Application No: EP/64/21/PL
Site Address: 111 Sea Road East Preston BN16 1NX
Description of works: Alterations to existing premises and change of use to Office. This site is in CIL Zone 4 (Zero Rated) as other development.

Thank you for your internet representation made on 8th July 2021 which has been recorded as an objection with the comments as follows:

I am commenting on behalf of the East Preston and Kingston Preservation Society.

| Revisions                                                                                                                                                    |             |    |
|--------------------------------------------------------------------------------------------------------------------------------------------------------------|-------------|----|
| Drawing Title:<br>Existing and Proposed Plans, Elevations, Site Location Plan and Site Block Plan                                                            |             |    |

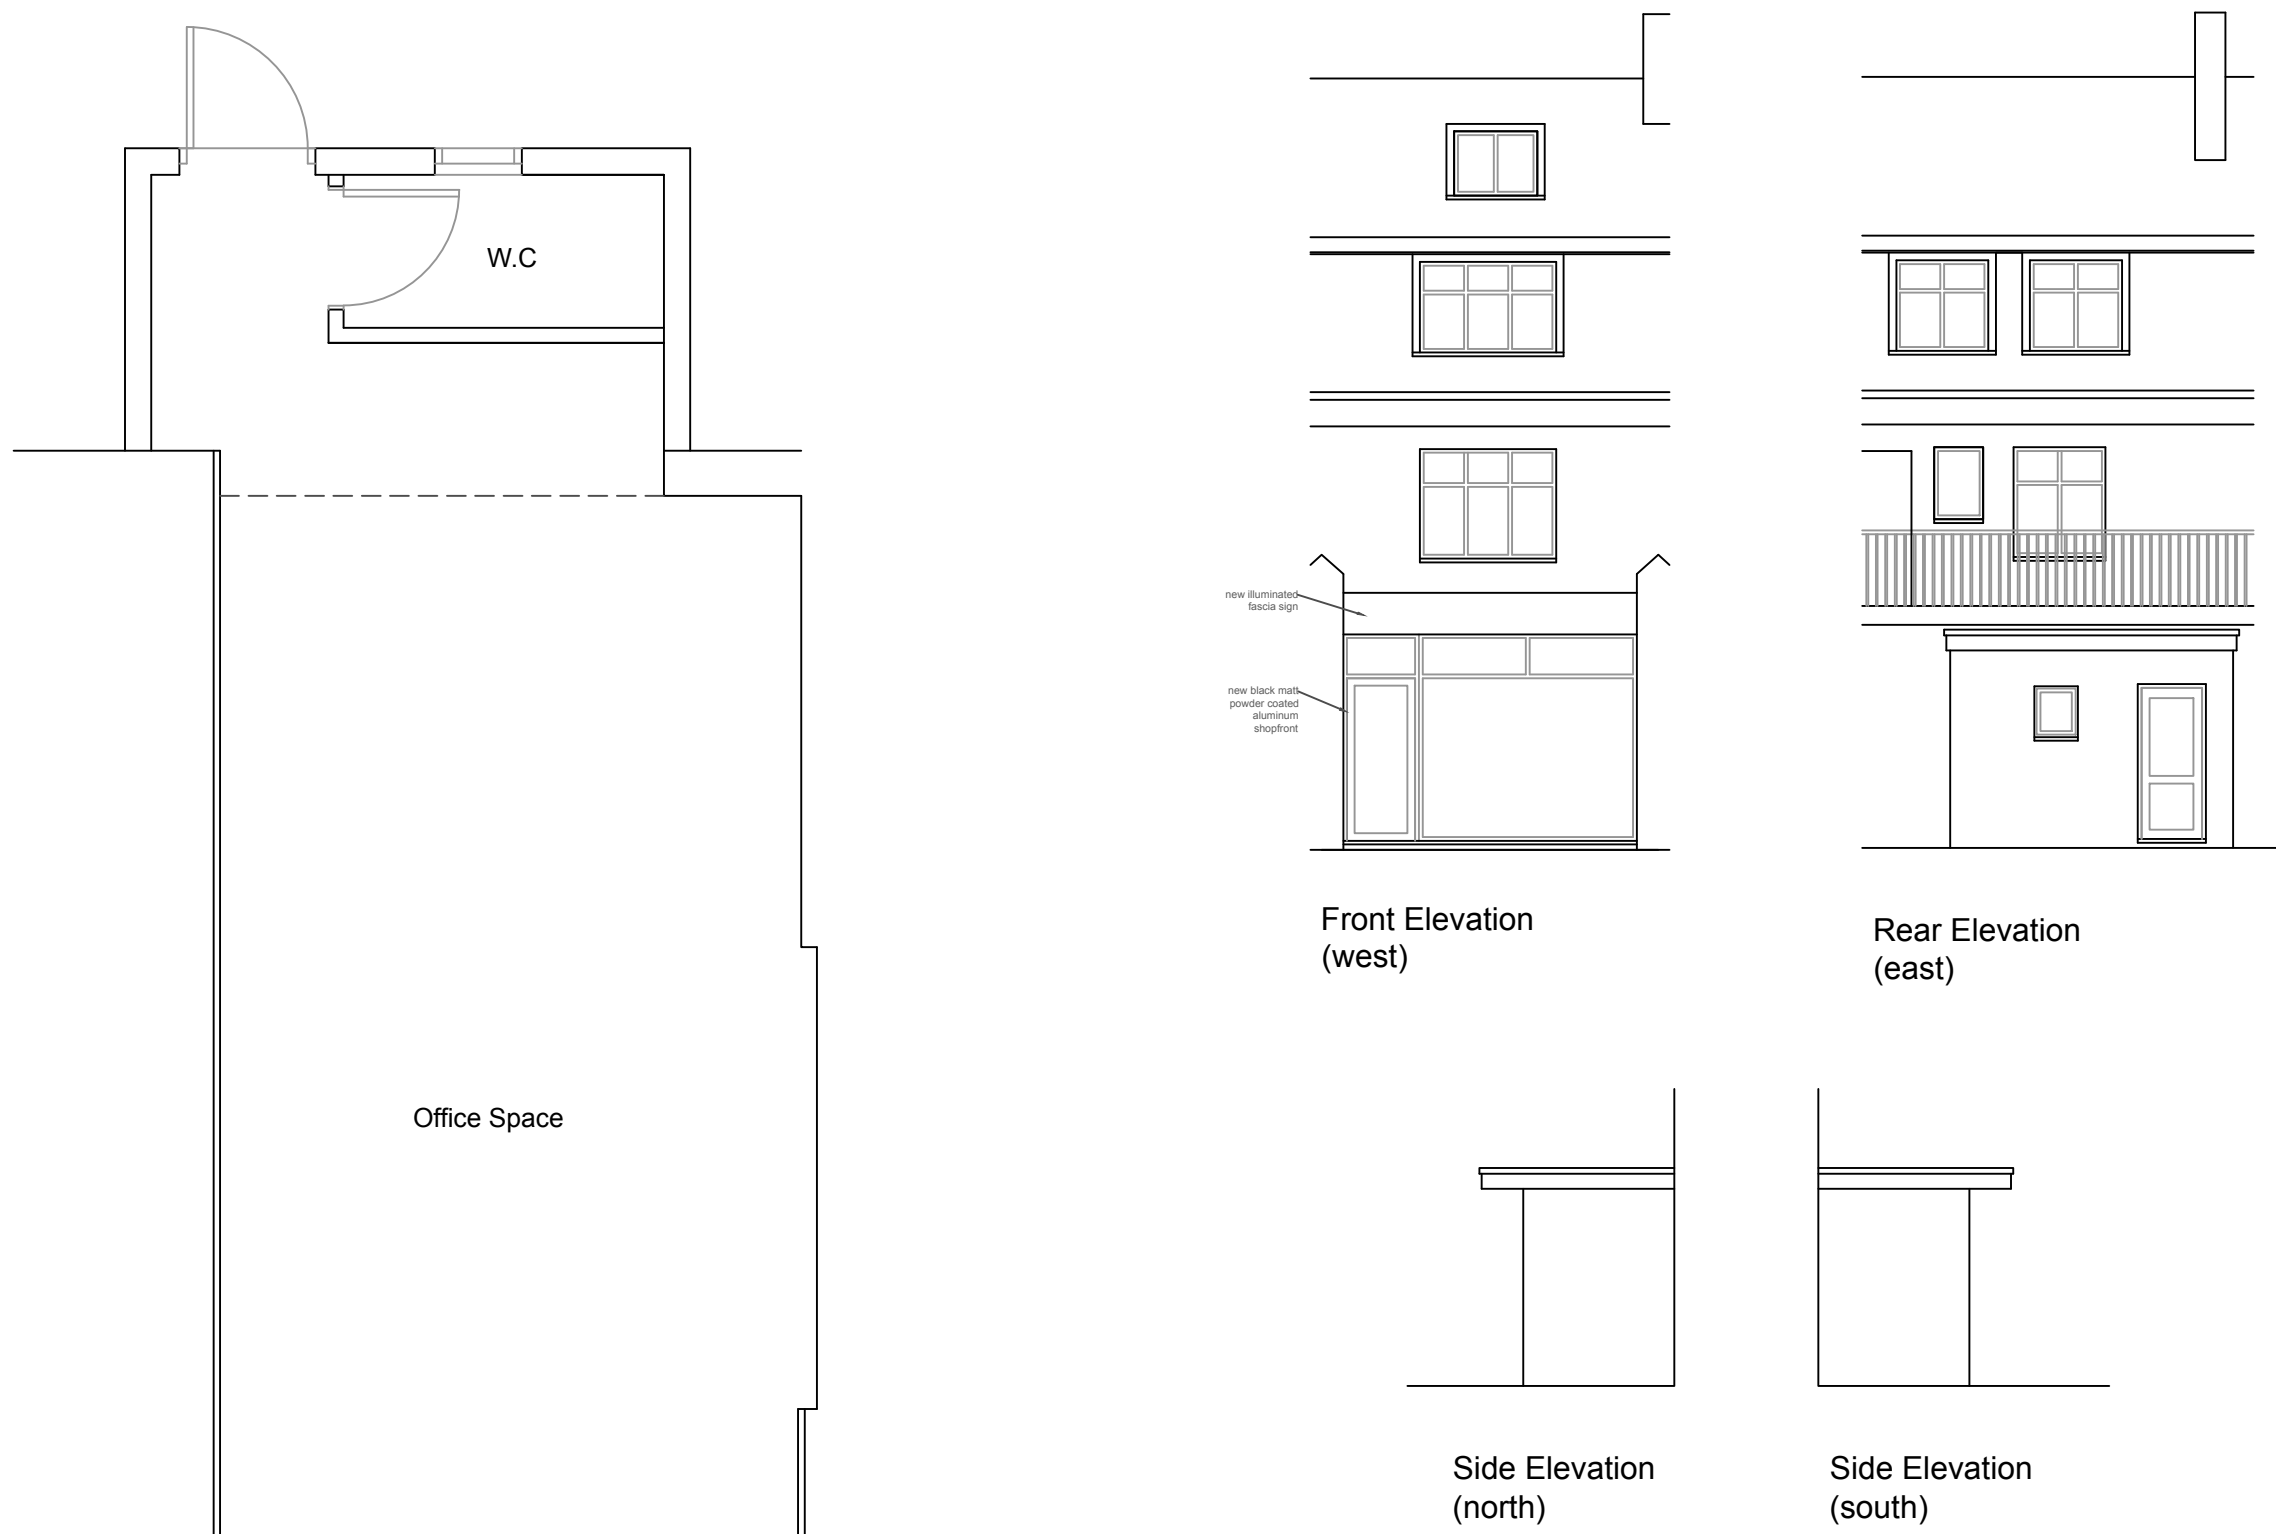
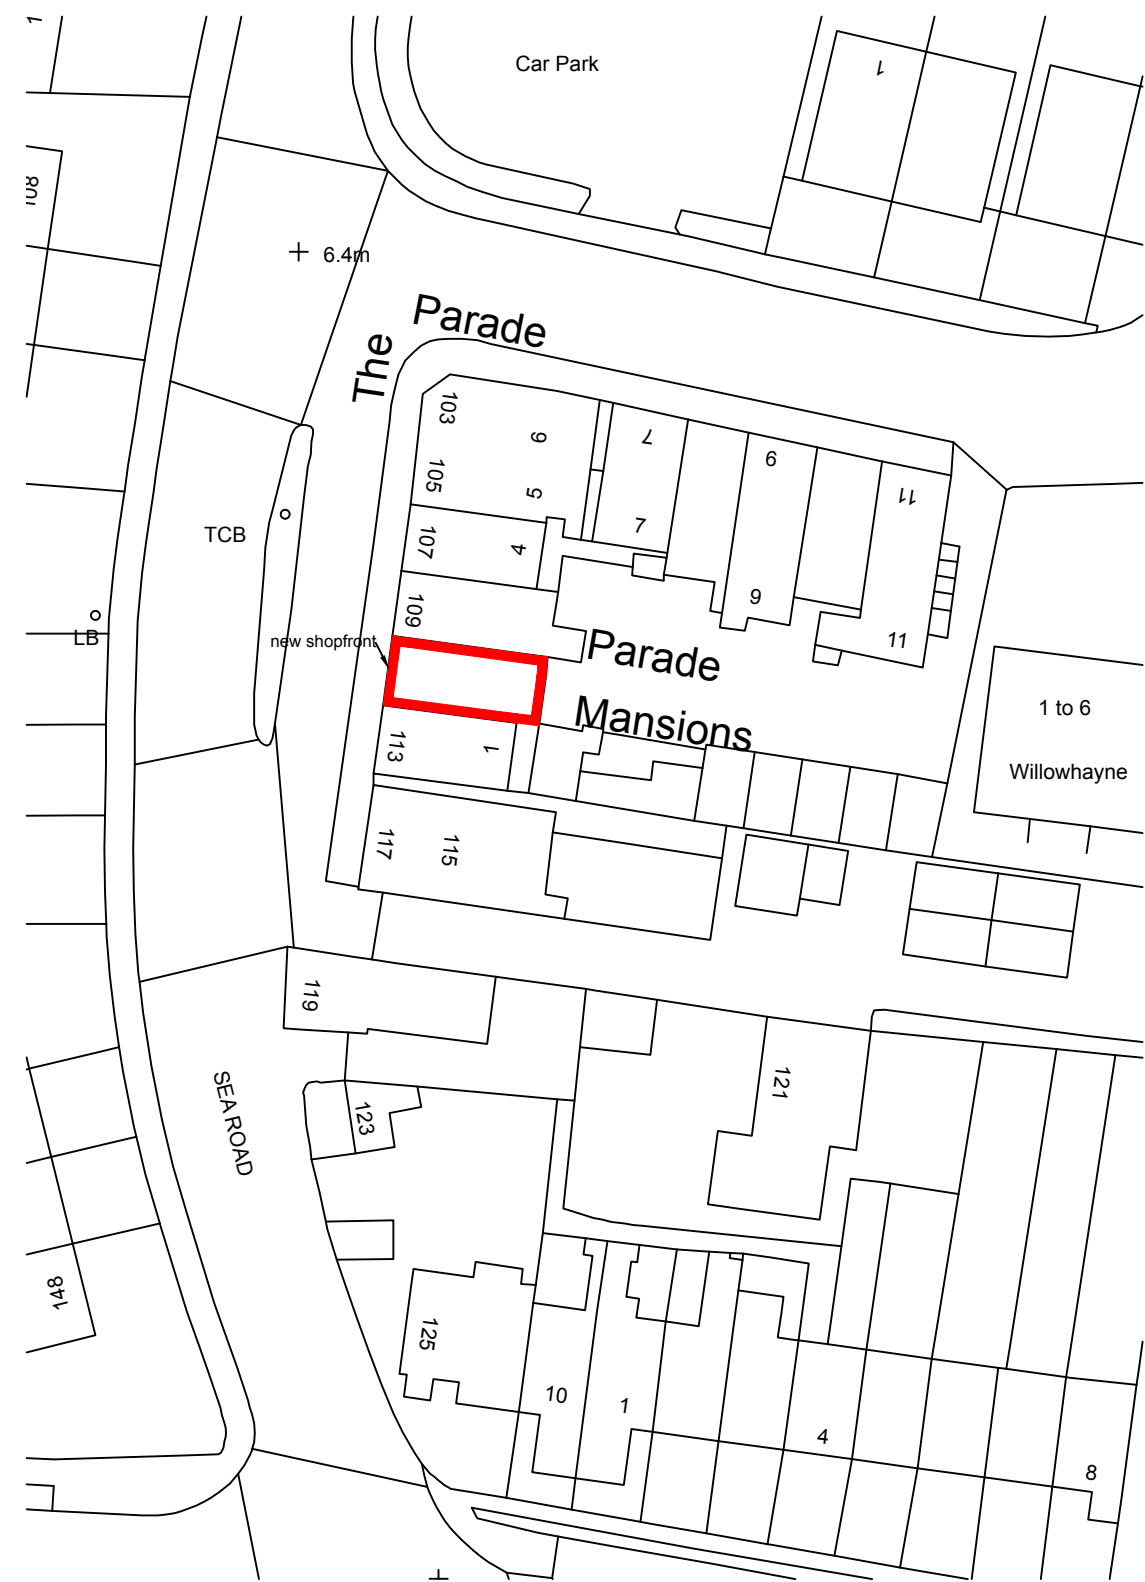
The proposal to replace a wooden shopfront with a black aluminium framed shop window is wholly inappropriate for these premises. They are in a block built in 1921-22, with shops on the ground floor and accommodation in the three upper floors. The block is a good example of the architectural style of that time, with half timbered walls and wooden shop fronts. Its original character has been retained in the century since it was built.

The proposed black aluminium shop window therefore clashes with the rest of the building, and introduces an undesirable break with the original design of the building.

Black aluminium is not an appropriate material for this building.

The proposal is contrary to Policy D DM1 of the Arun Local Plan, because the materials do not reflect those in the surround area; it is contrary to Policy D DM4 of the Local Plan because it does not respect the building; it is contrary to Policy HER DM2 because it would harm a building nominated for the Local List; and it would be contrary to Policy 1 of the East Preston Neighbourhood Plan because it would not reflect the architectural and historical character of surrounding buildings.
